Cherwell District Council
Planning & Development Services
Bodicote House White Post Road
Bodicote
Banbury
OX15 4AA

Our ref: WA/2021/129037/01-L01
Your ref: 21/01119/OUT
Date: 21 May 2021

Outline planning application for the re-development of the banbury oil depot to include the demolition/removal of buildings and other structures associated with the oil depot use and the erection of up to 143 apartments and up to 166m2 of community and/or retail and/or commercial space (class use E and/or F2) with all matters (relating to appearance landscaping, scale and layout) reserved except for access off tramway road

Q8 Fuelcare, Tramway Road, Banbury, OX16 5TD

The Illustrative Masterplan

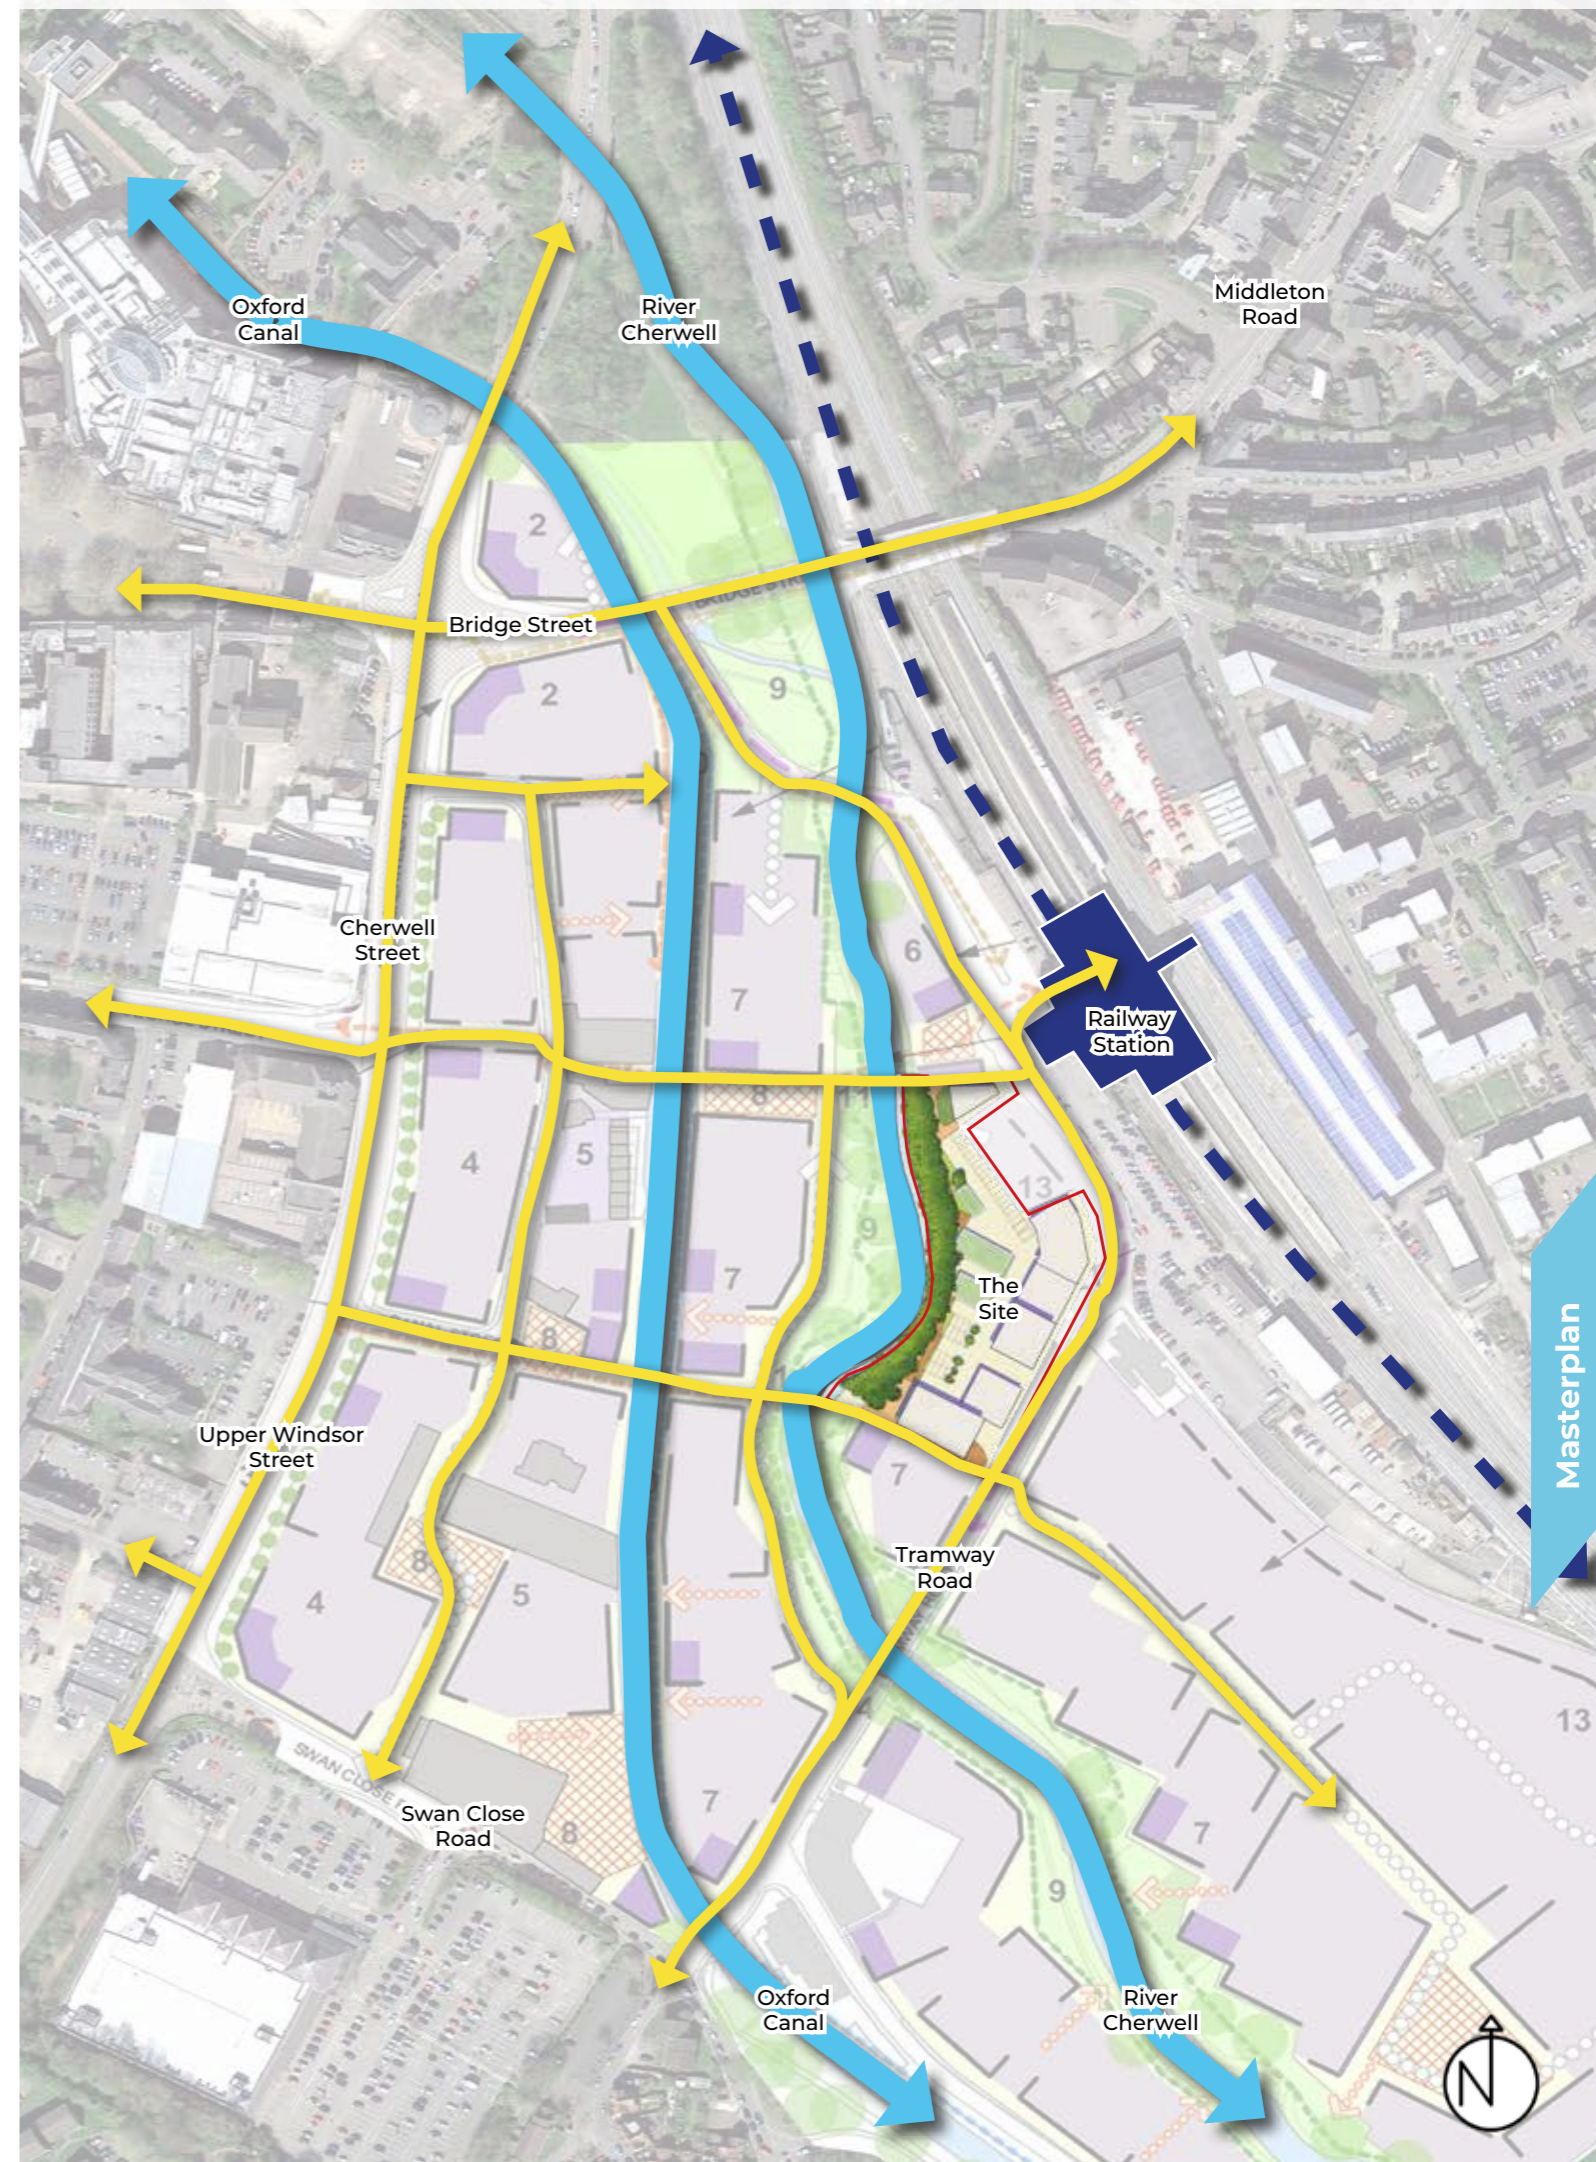
For any potential loss of flood storage based on the illustrative masterplan for the site, direct replacement of flood storage should be provided through floodplain compensation. This is necessary to ensure that the site can accommodate the amount of development being proposed without increasing flood risk elsewhere and that sufficient space for flood storage is protected.

While landscaping is a reserved matter and details of planting and management regimes can be dealt with later, the principals of protecting and enhancing the sites value for biodiversity need to be established to inform future design phases. The illustrative masterplan and landscape plan show significant development in the form of parking, amenity space, footpaths and raised platforms adjacent to the river. We will object to this design if pursued. The vegetation cannot be retained and managed for biodiversity value if these features fall within it. An 8 – 10 metre biodiversity zone should be provided which is designed and managed to improve the ecological value of the development.

Figure 7-1: Flood Depths - Defended 0.1% annual probability (1 in 1000 year) event – Station

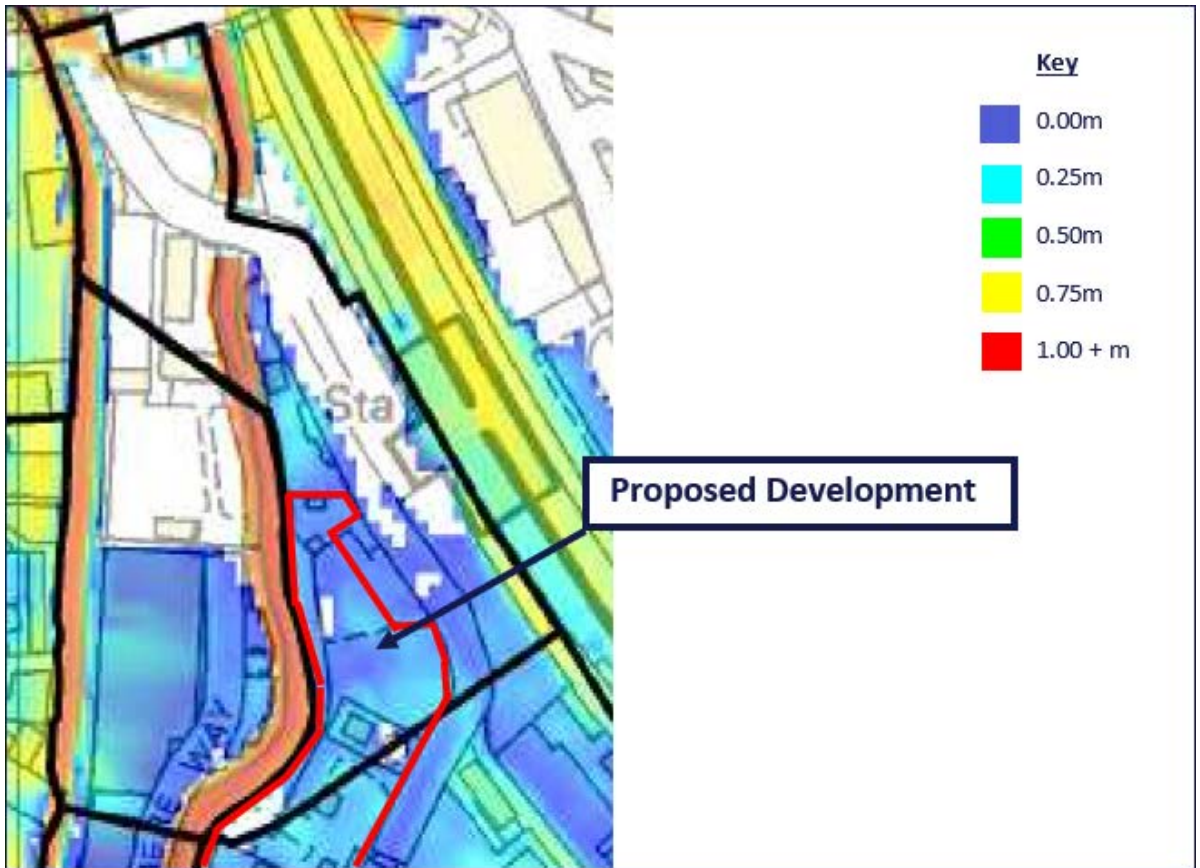
- Take the impacts of climate change into account as there is no assessment of the impact of climate change using appropriate allowances in accordance with government guidance.
- Fails to identify mitigation measures for any loss of flood storage during a 1% climate change event as a result of the development
- Consider how people will be kept safe from flood hazards
- Fails to identify suitable finished floor levels for the development, in particular the residential dwellings

The FRA should map the expected extents and depths of a range of critical flood events up to and including a 1% annual probability event with an appropriate allowance for climate change in accordance with the following guidance : ['Flood risk assessments: climate change allowances'](#). More Vulnerable development in flood zones 2 or 3 should use the higher central and upper end allowances. Flood extents should be mapped in accordance with a detailed topographical survey of the site.

In this instance the available Environment Agency data for this area only includes a 20% allowance for climate change which is not sufficient for use within the FRA. The applicant may need to undertake revised fluvial modelling to establish the climate change flood levels for the FRA.

Finished floor levels should be set as high as possible above the 1% climate change flood level. Raising finished floor levels is the most robust way of ensuring the development is safe from the risk of flooding. Using flood resistant or resilient construction measures is considered an additional benefit but should not be relied upon alone to prevent internal flooding.
